Application by RWE Renewables UK Solar and Storage Limited for Tween Bridge Solar Farm Project
The Examining Authority's written questions and requests for information (ExQ1): Issued on 24 April 2026
Responses are due by deadline 2: 19 May 2026

Please find below answers to the Examining Authority's written questions from the Environment Agency (EA) [ref no. F1C2DDF91].

TWEEN BRIDGE – DRAINAGE STRATEGY INDICATIVE SURFACE WATER OUTFALLS

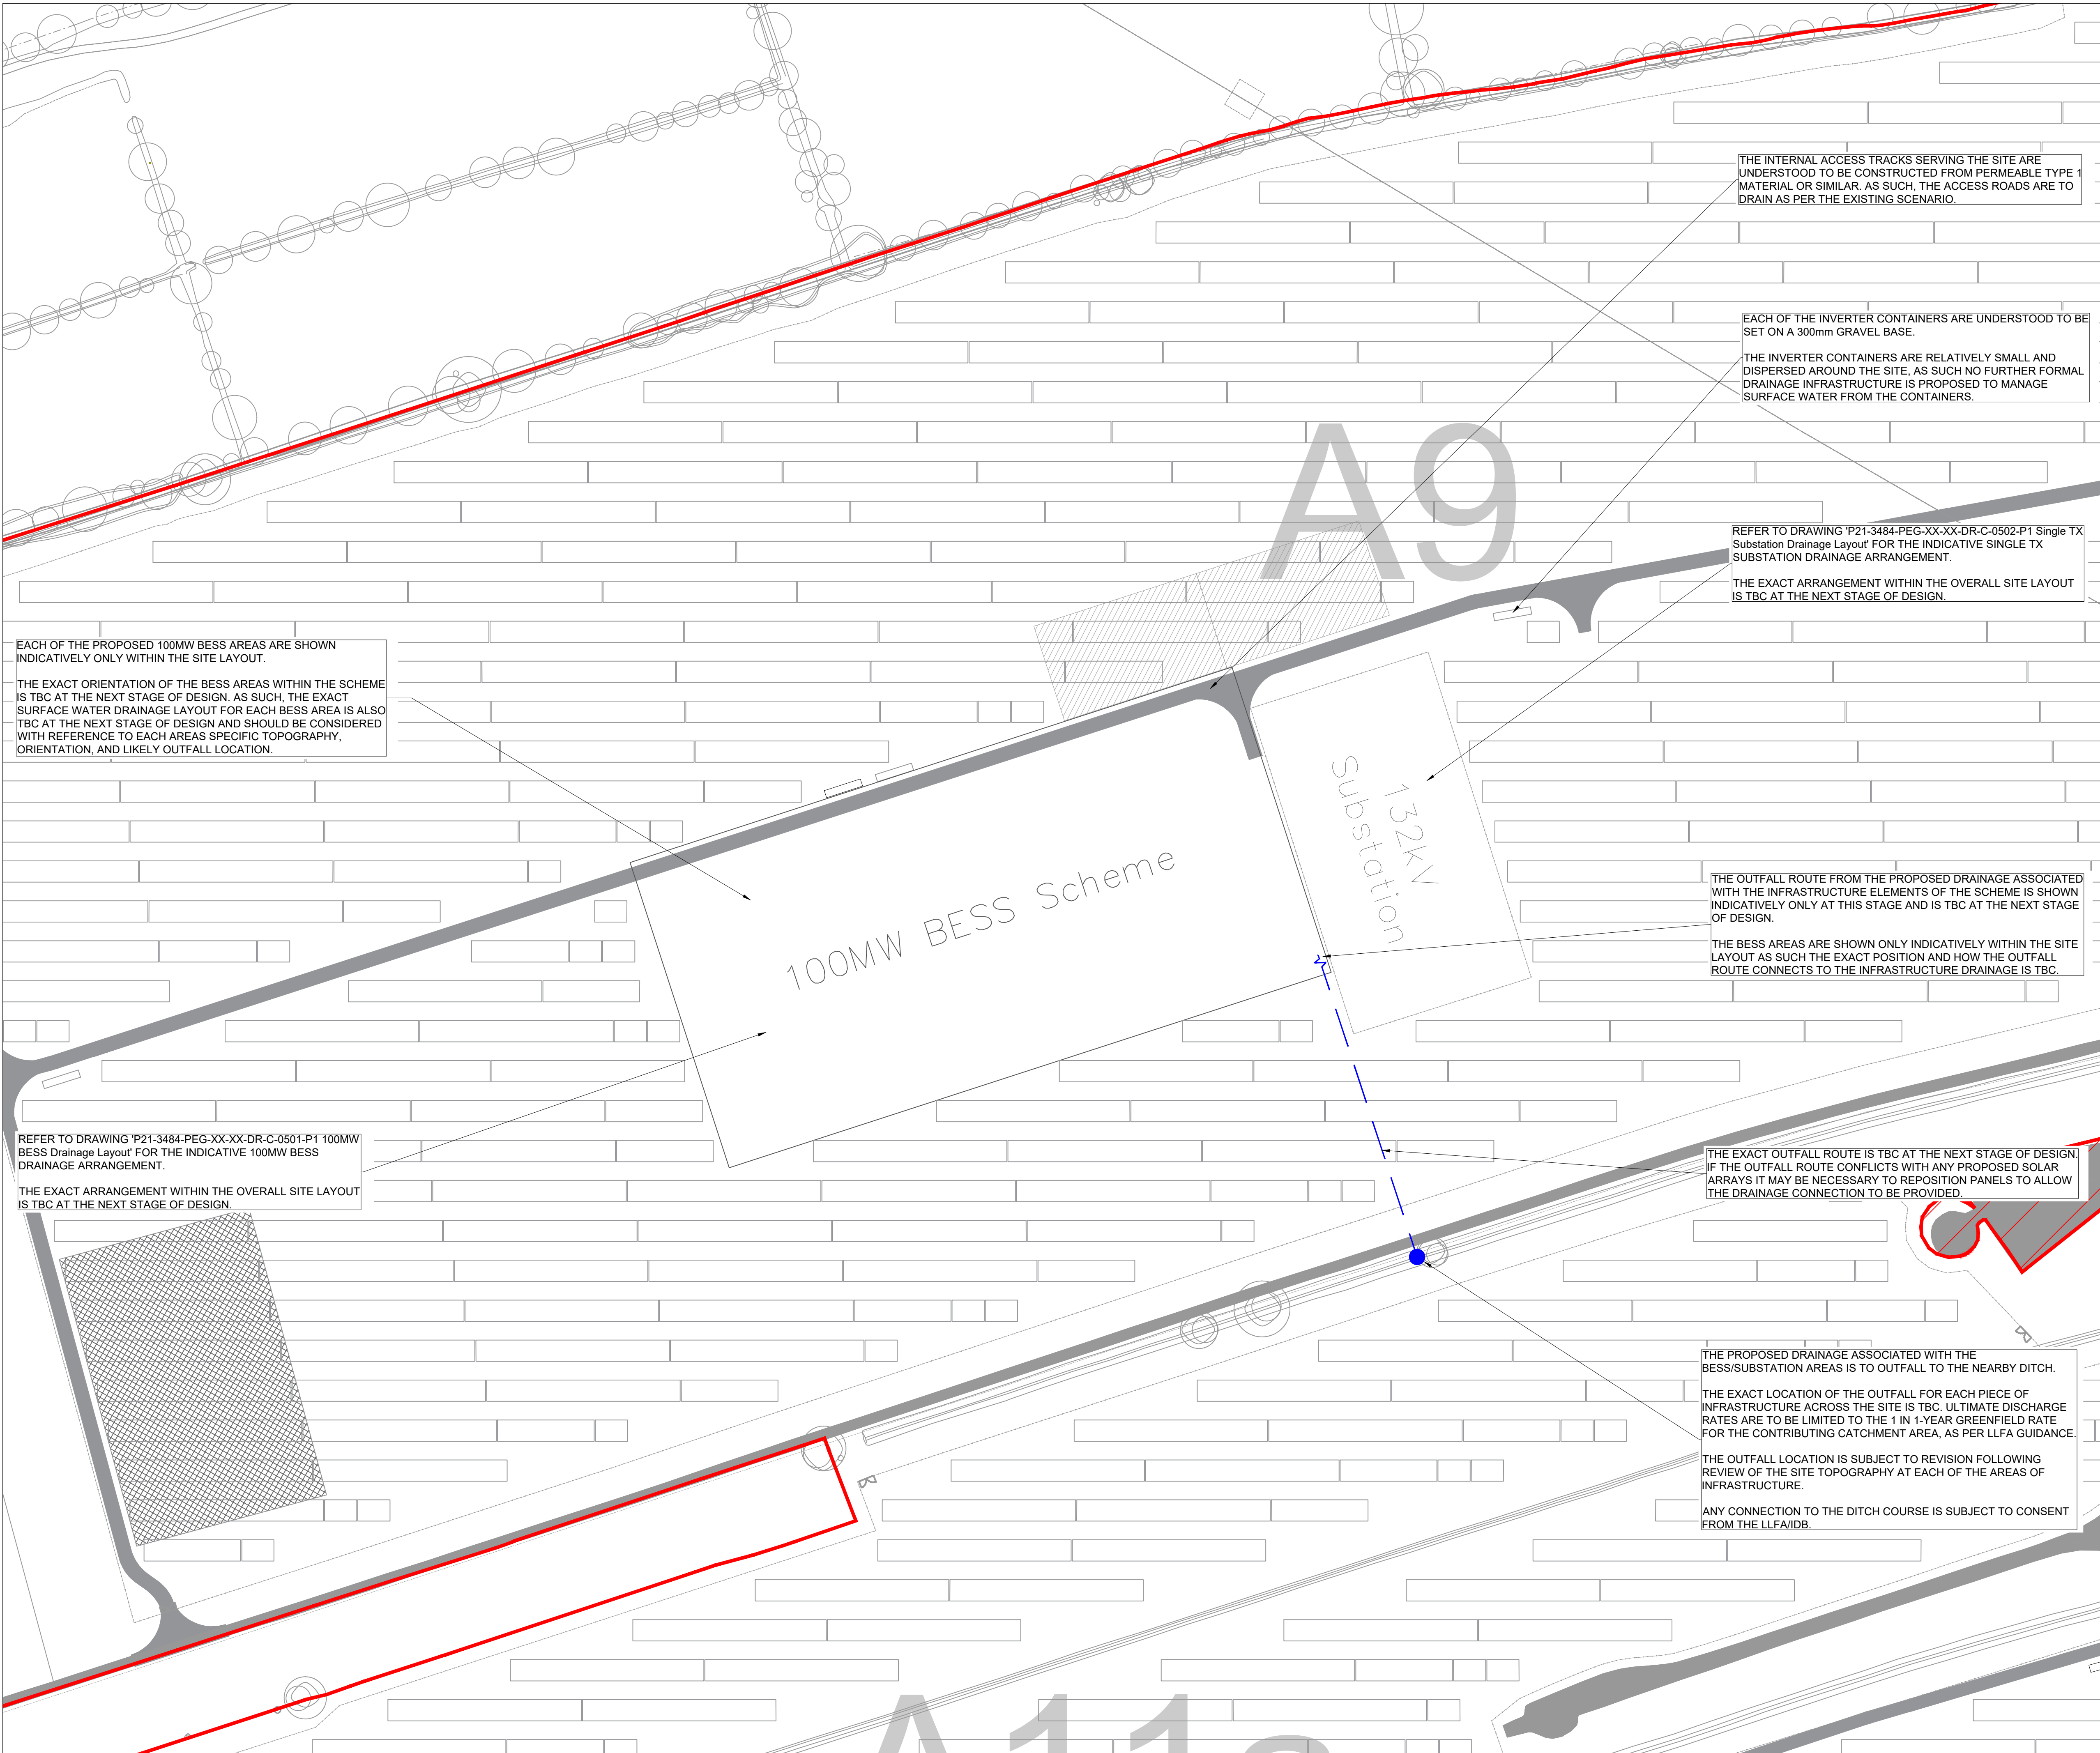
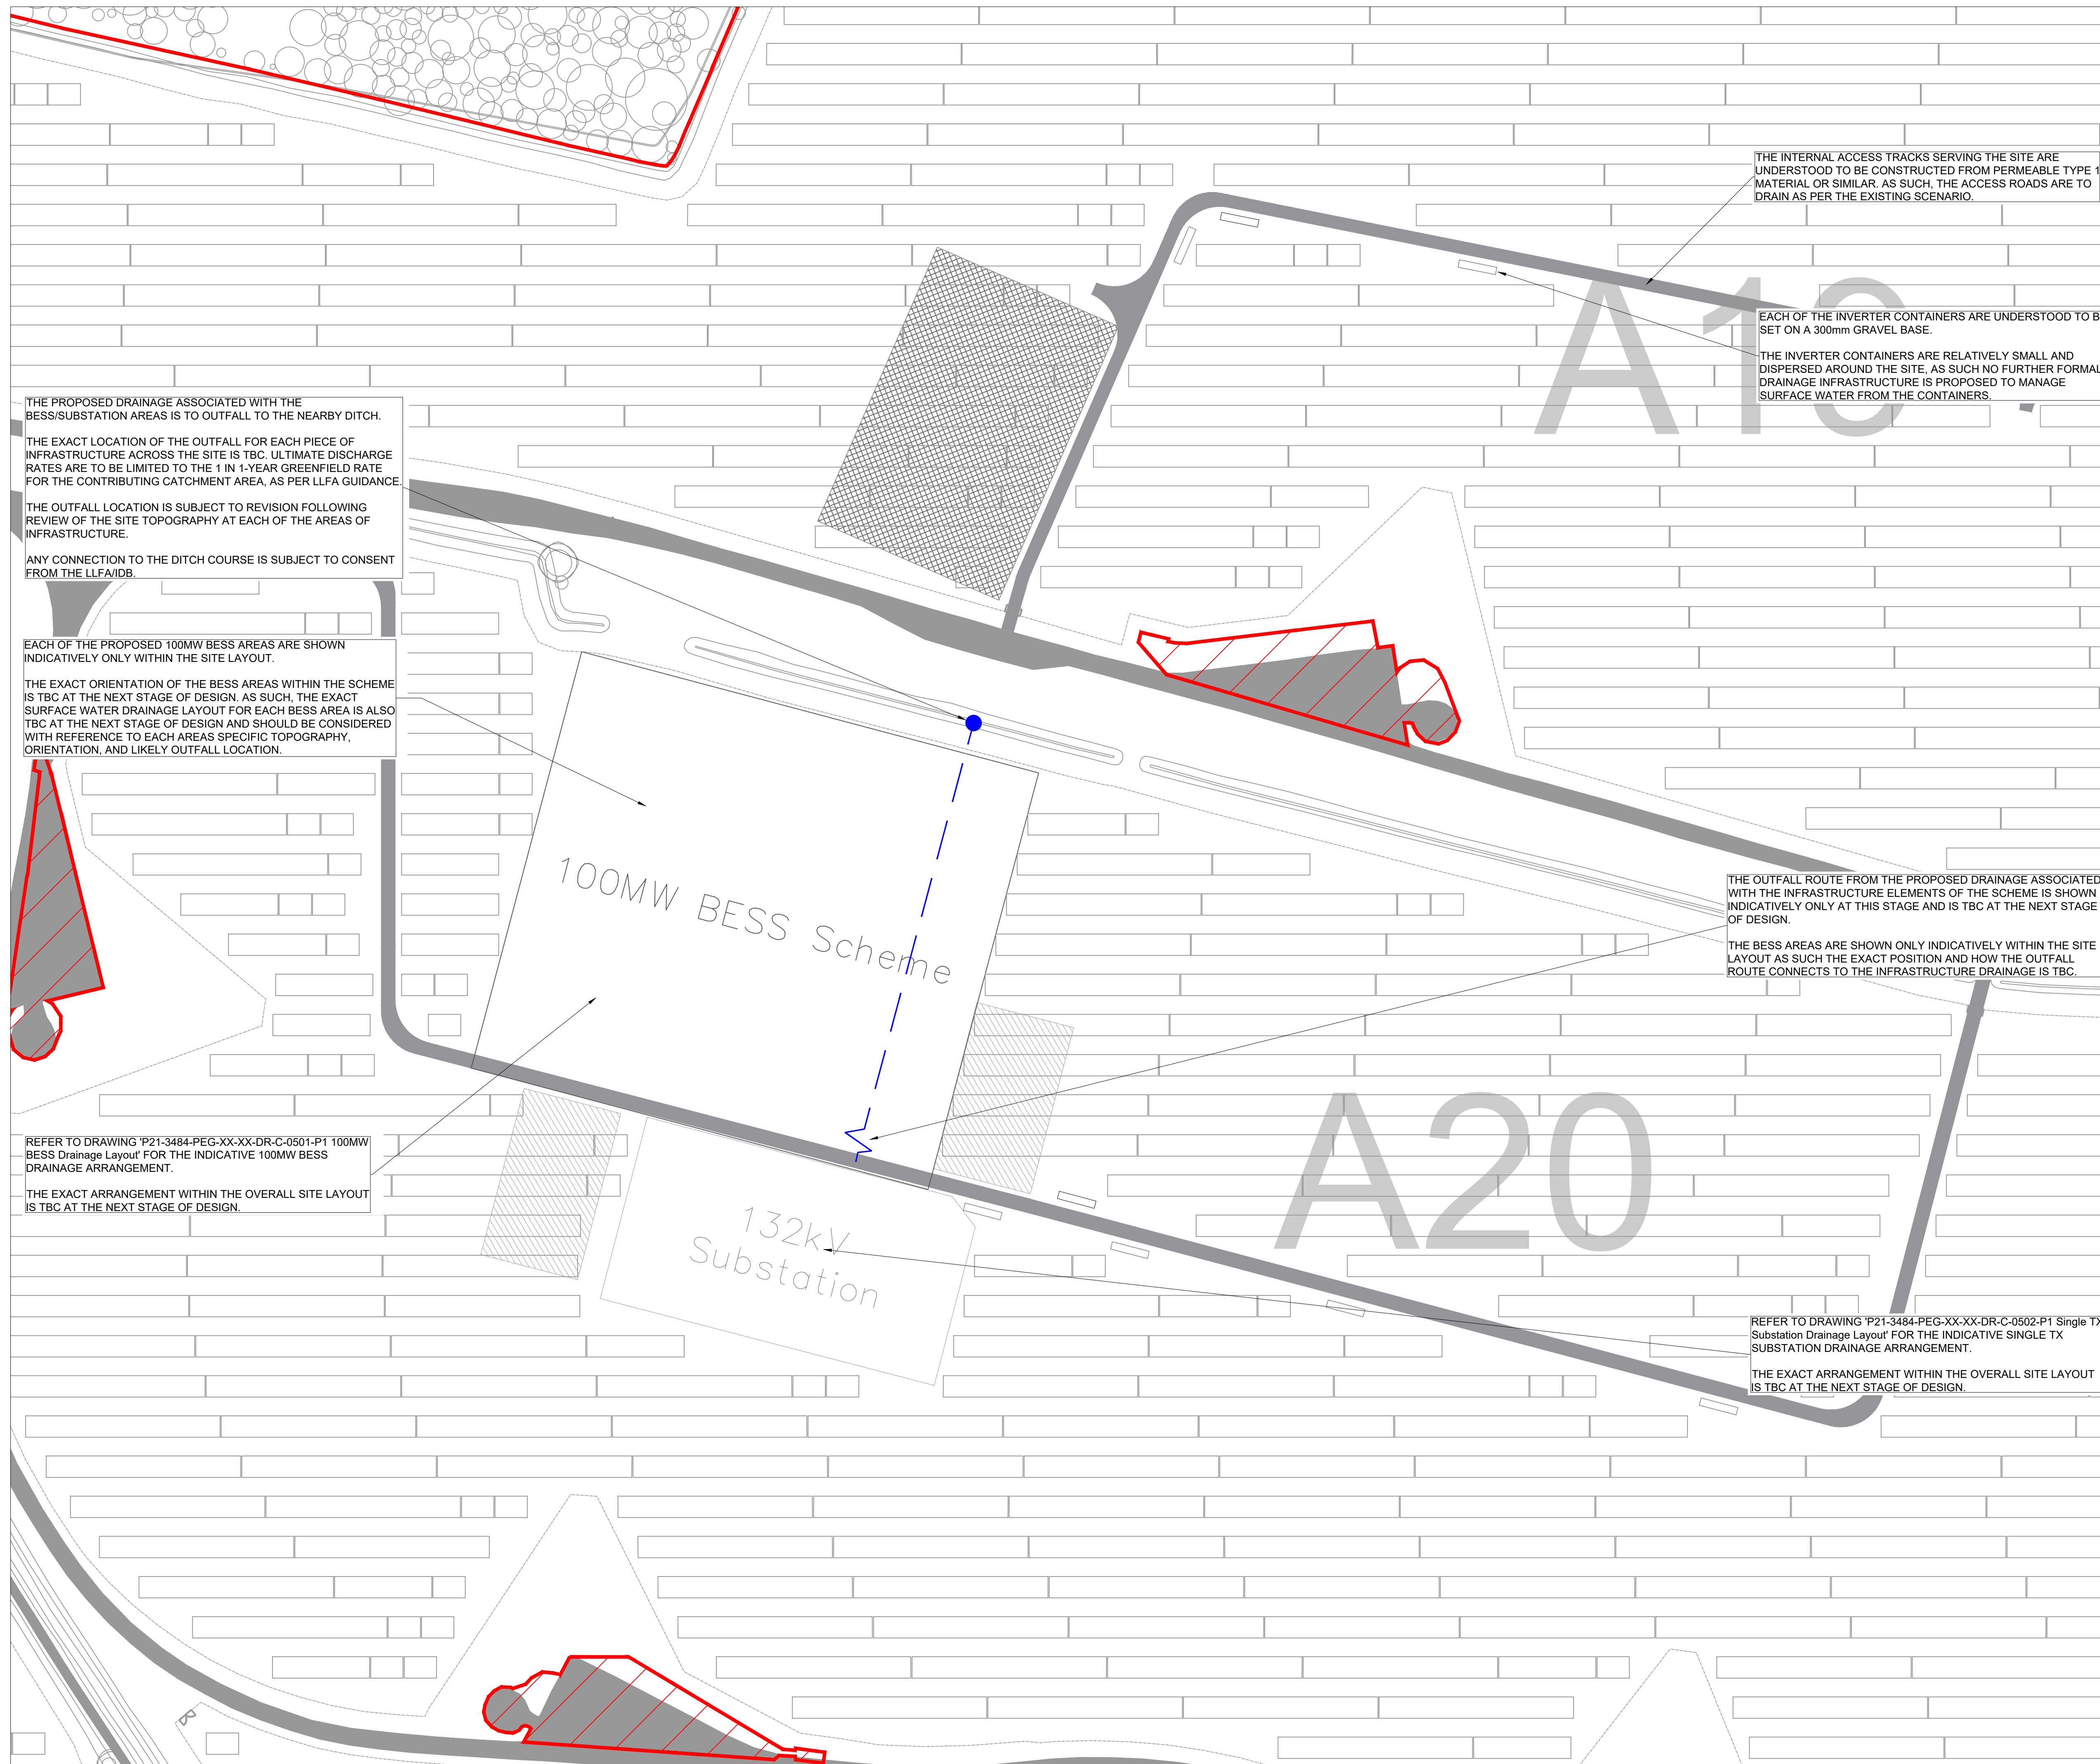
Ref No.	Question	EA response
Q7.0.22	<p>Outline Surface Water Drainage Strategy</p> <p>Could the EA and Council's please confirm the acceptability or otherwise (in principle) of the outline surface water drainage strategy at FRA section 7 and appendices I and J [APP-108-109]?</p>	<p>The EA can confirm that (in principle) it considers the outline surface water drainage strategy is acceptable. We will need to have further discussions with the applicant at the detailed design stage to confirm and agree the strategy in relation to the protection of Controlled Waters. We are satisfied that our inclusion as a specific consultee to Requirement 7 (Battery safety management plan) and Requirement 11 (Surface and foul water drainage) will enable us to do this.</p>
Q7.0.31	<p>Operational reason for locating in flood zone 3b</p> <p>NPS EN-1 paragraph 5.8.41 states in full: <i>“Energy projects should not normally be consented within Flood Zone 3b , or Zone C2 in Wales, or on land expected to fall within these zones within its predicted lifetime. This may also apply where land is subject to other sources of flooding (for example surface water). However, where essential energy infrastructure has to be located in such areas, for operational reasons, they should only be consented if the development will not result in a net loss of floodplain storage, and will not impede water flows.”</i></p> <p>Please could the applicant explain whether there are any operational reasons why this development needs to be located within flood zone 3b?</p>	<p>The EA can confirm that the project will not impact on the available flood storage capacity within Flood Zone 3b. The EA holds no view on the operational reasons why the development needs to be located within Flood Zone 3b.</p>
